NJA Ref: 21/232

16 June 2021

LPA Ref: FG/90/21/HH
Proposal: Erection of addition of second floor, part single, part two storey extension and wrap around terrace
Site: 1 Sea Drive, Ferring, BN12 5HD

Project: Extension & Refurbishment	
for Chris Levett	
at 1 Sea Drive Ferring Worthing BN12 5HD	
Contact: Michael Austin R/BA	
E-mail: project@austinlebbon.co.uk	
Web: www.austinlebbon.co.uk	
Phone: 07958427610	
Dwg Ref: 2048 [PL] 05	Rev: - Date: May 2021

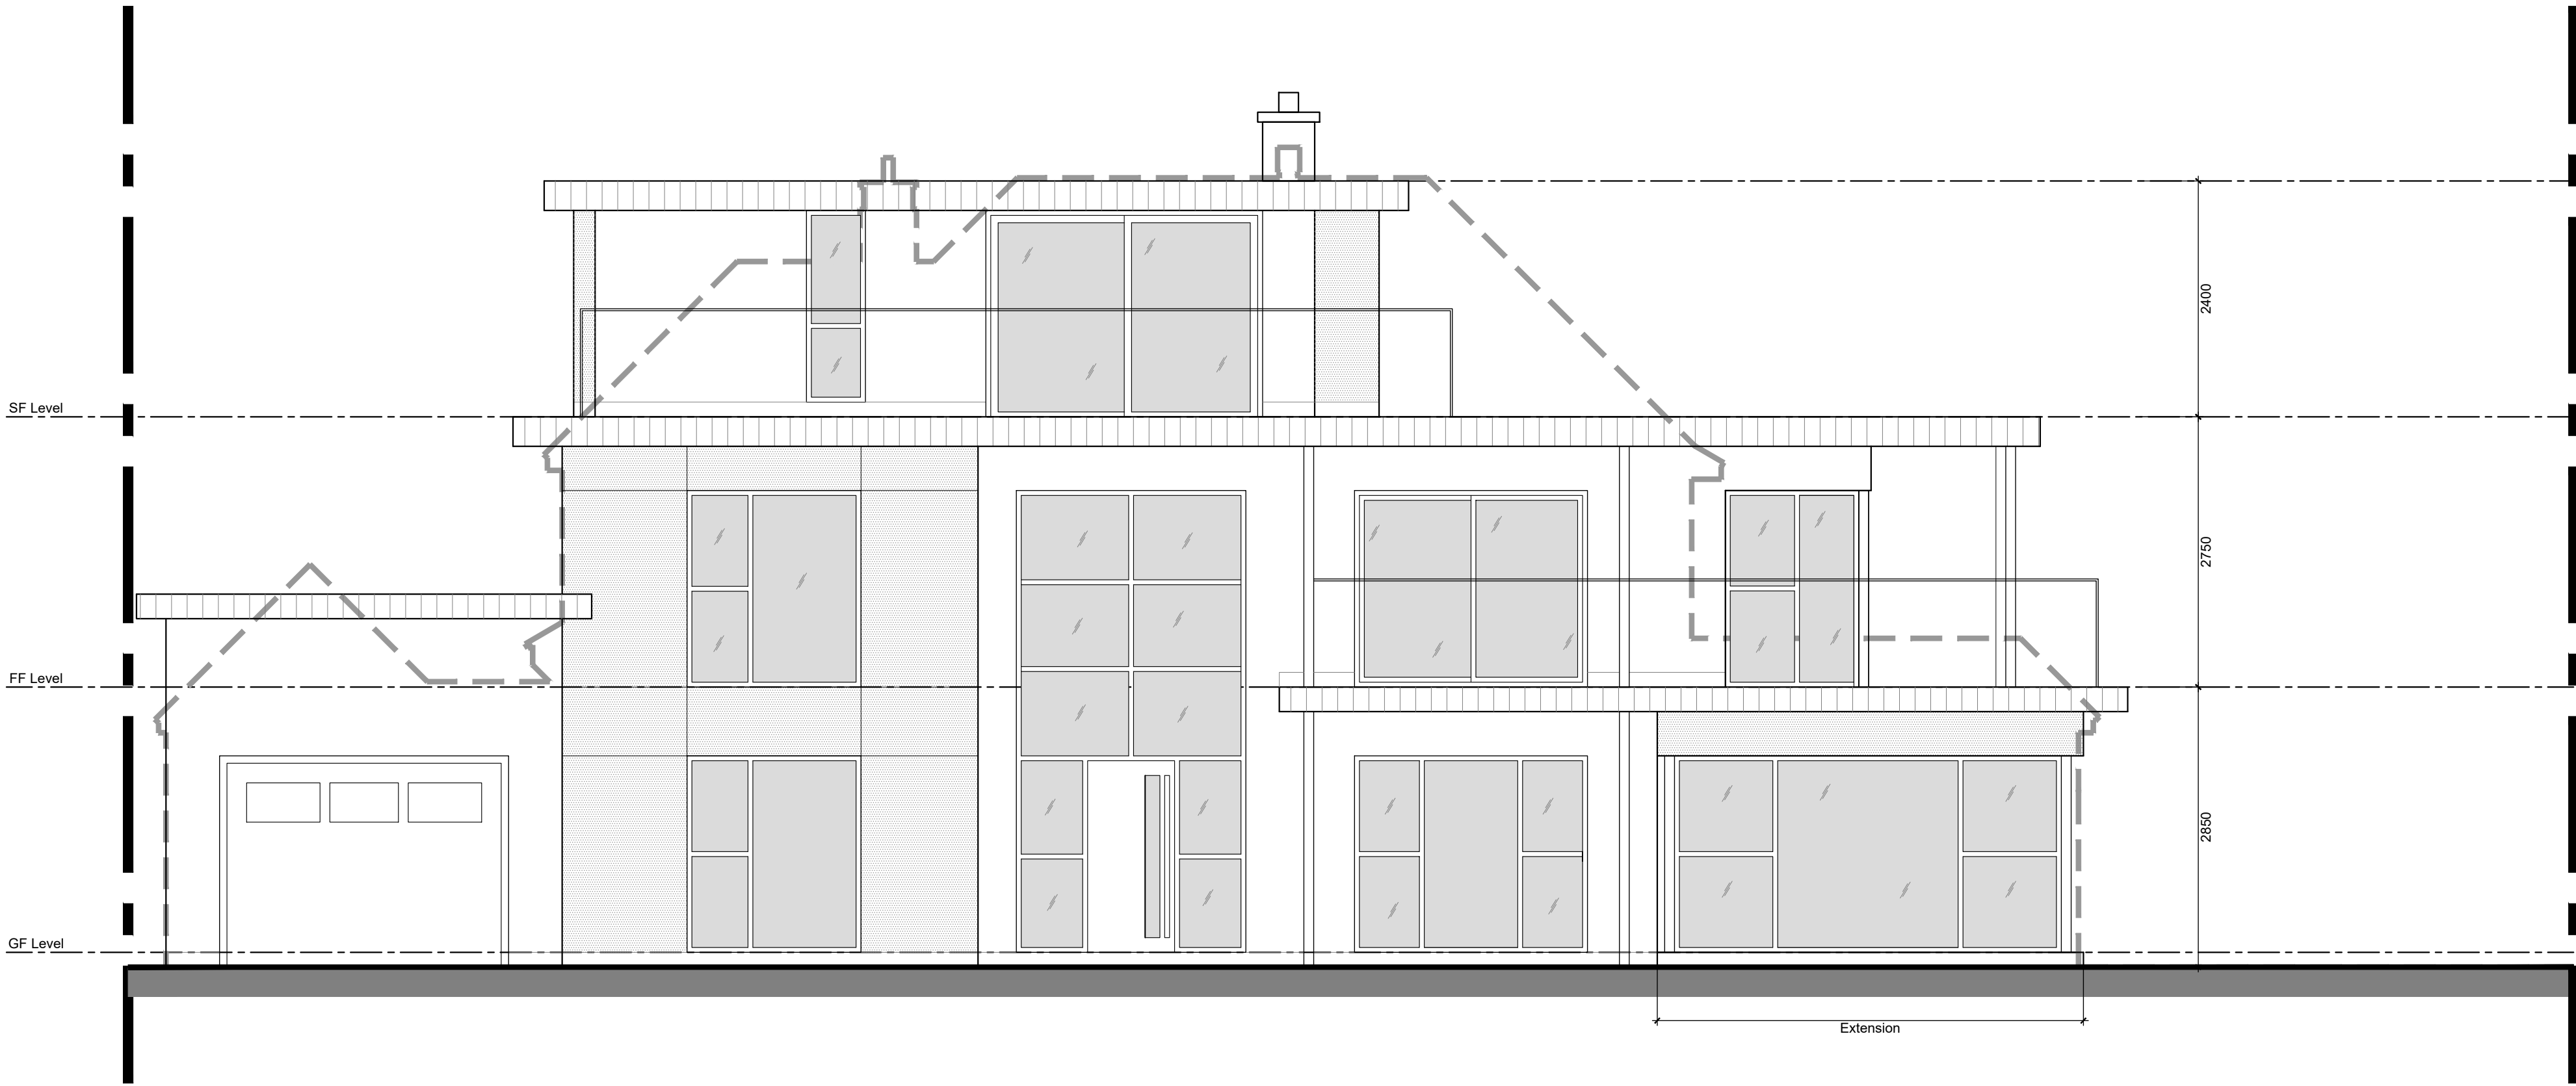
The proposed terrace above the existing garage has the potential to cause unacceptable levels of noise and disturbance given its size and proximity to the common boundary. Furthermore, the wall surrounding the terrace is low which will allow for harmful overlooking of private amenity space at number 3, including the front first floor balcony which itself was specifically designed to respect the privacy of the occupiers of number 1. The front garden at number 3 is a well-used amenity space due to its southerly aspect and as such the owners have created a patio area in this location. It is also a private and enclosed space and given its use this area should be afforded the same weight as the rear garden of the property in considering impact upon privacy.

In addition, the proposed first floor patio doors to the terrace and second floor window to the western elevation of the dwelling will allow unacceptable direct views into the first floor balcony (less than 1 ft away) and front and rear garden areas at number 3. Currently there is only one first floor dormer window to the west elevation of number 1 which is a later addition, set into the roof slope away from the boundary and which is fitted with obscure glass (as required by condition). Therefore, the existing situation to this elevation would be substantially altered through the creation of a large terrace and new windows that would be detrimental to the residential amenity of number 3 by reason of loss of privacy caused by overlooking and the potential for harmful noise and disturbance.

In terms of the proposed second floor balcony to the east and south elevations of the dwelling, this would also unacceptably overlook the balcony and private front garden area at number 3 along with the possibility for direct views across and down into the velux window in the dwelling's east facing roof slope which serves a bedroom. This balcony (along with the proposed terraced and west facing windows) would have a further detrimental impact upon the amenity of number 3 as a result of harmful and unacceptable overlooking causing loss of privacy. The plans do not indicate the type of screening to the proposed second floor balcony but even with a screen, its impact combined with the proposed terrace, west facing windows and the proposed wrap around first floor terrace to the

The proposal includes substantial changes to the design of number 1 including its roof form which will be altered from a pitched to a modern flat roof design. This will result in a dramatic alteration to the dwelling's present chalet style appearance, changing it to a three storey dwelling. As a result, the dwelling will appear very overbearing to number 3 and given the addition of a second floor and substantial overall increase in scale and bulk, it will unacceptably block light to the private amenity spaces at number 3.

Due to the present chalet style design of number 1, the only windows to the rear elevation of the dwelling at first floor level are three small windows set into the roof slope. However, the proposal in contrast includes the insertion of a large number of ground, first and second floor windows and doors to all elevations. The number, siting and full length design of the windows and doors would appear excessive and would unacceptably overlook the private garden areas at number 3 and the rear garden of the dwelling to the north, 108 Sea Lane. The combined appearance of these windows would create an oppressive feel to neighbours and the level of overlooking would be detrimental to privacy and wholly unacceptable.
